**Our ref:** WA/2021/129037/02-L01  
**Your ref:** 21/01119/OUT  
**Date:** 24 May 2022

**Outline planning application for the re-development of the banbury oil depot to include the demolition/removal of buildings and other structures associated with the oil depot use and the erection of up to 143 apartments and up to 166m2 of community and/or retail and/or commercial space (class use E and/or F2) with all matters (relating to appearance landscaping, scale and layout) reserved except for access off tramway road**

**Q8 Fuelcare, Tramway Road, Banbury, OX16 5TD**

Figure 7-1: Flood Depths - Defended 0.1% annual probability (1 in 1000 year) event – Station

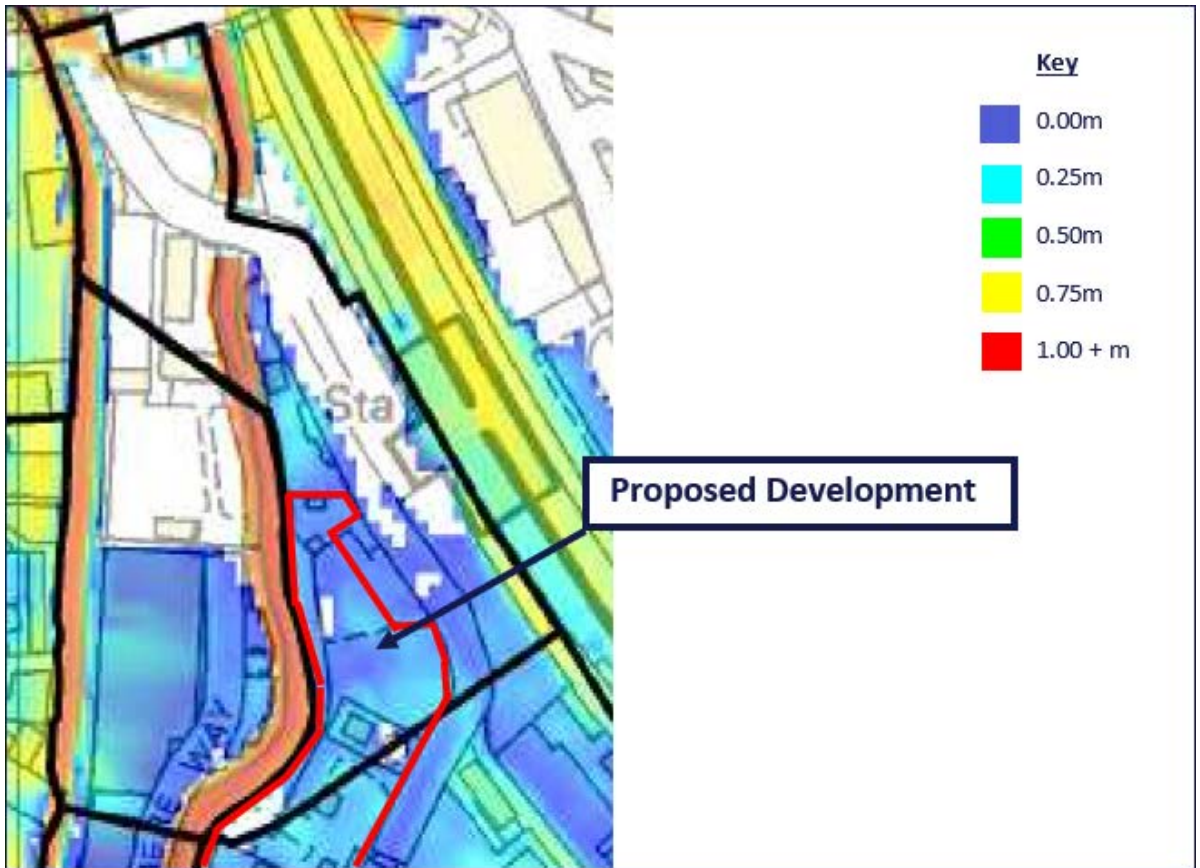
In our previous response, dated 21 May 2021, we advised that the Flood Risk Assessment (FRA) had not sufficiently considered the risks associated with flooding based on the most up to date evidence and had not considered future flood risk due to climate change. The revised FRA is still inadequate in this regard, and we therefore **maintain our objection** to this application.

In May 2021, we advised that the baseline evidence within the FRA was out of date and that the applicant should contact us for the most current and up to date data to include within the assessment. This remains outstanding and therefore the extent of flood risk at the site remains unclear.

We reiterate that the FRA should map the expected extents and depths of a range of critical flood events up to and including a 1% annual probability event with an appropriate allowance for climate change in accordance with the following guidance : 'Flood risk assessments: climate change allowances'. More Vulnerable development in flood zones 2 or 3 should use the higher central and upper end allowances. Flood extents should be mapped in accordance with a detailed topographical survey of the site.

Based on the proposed illustrative plans for the site, the FRA should identify that any potential loss of flood storage due to the development can feasibly be replaced on site, on land outside of the 1% climate change extent. This is necessary to ensure that the site can accommodate the amount of development being proposed without increasing risk elsewhere and that it is feasible for sufficient space for flood storage to be provided. The FRA must also consider the feasibility of raising internal floor levels above the 1% climate change flood level.

To overcome our objection, the applicant should submit a revised FRA which addresses the points highlighted above and within our previous response of 21 May 2021.
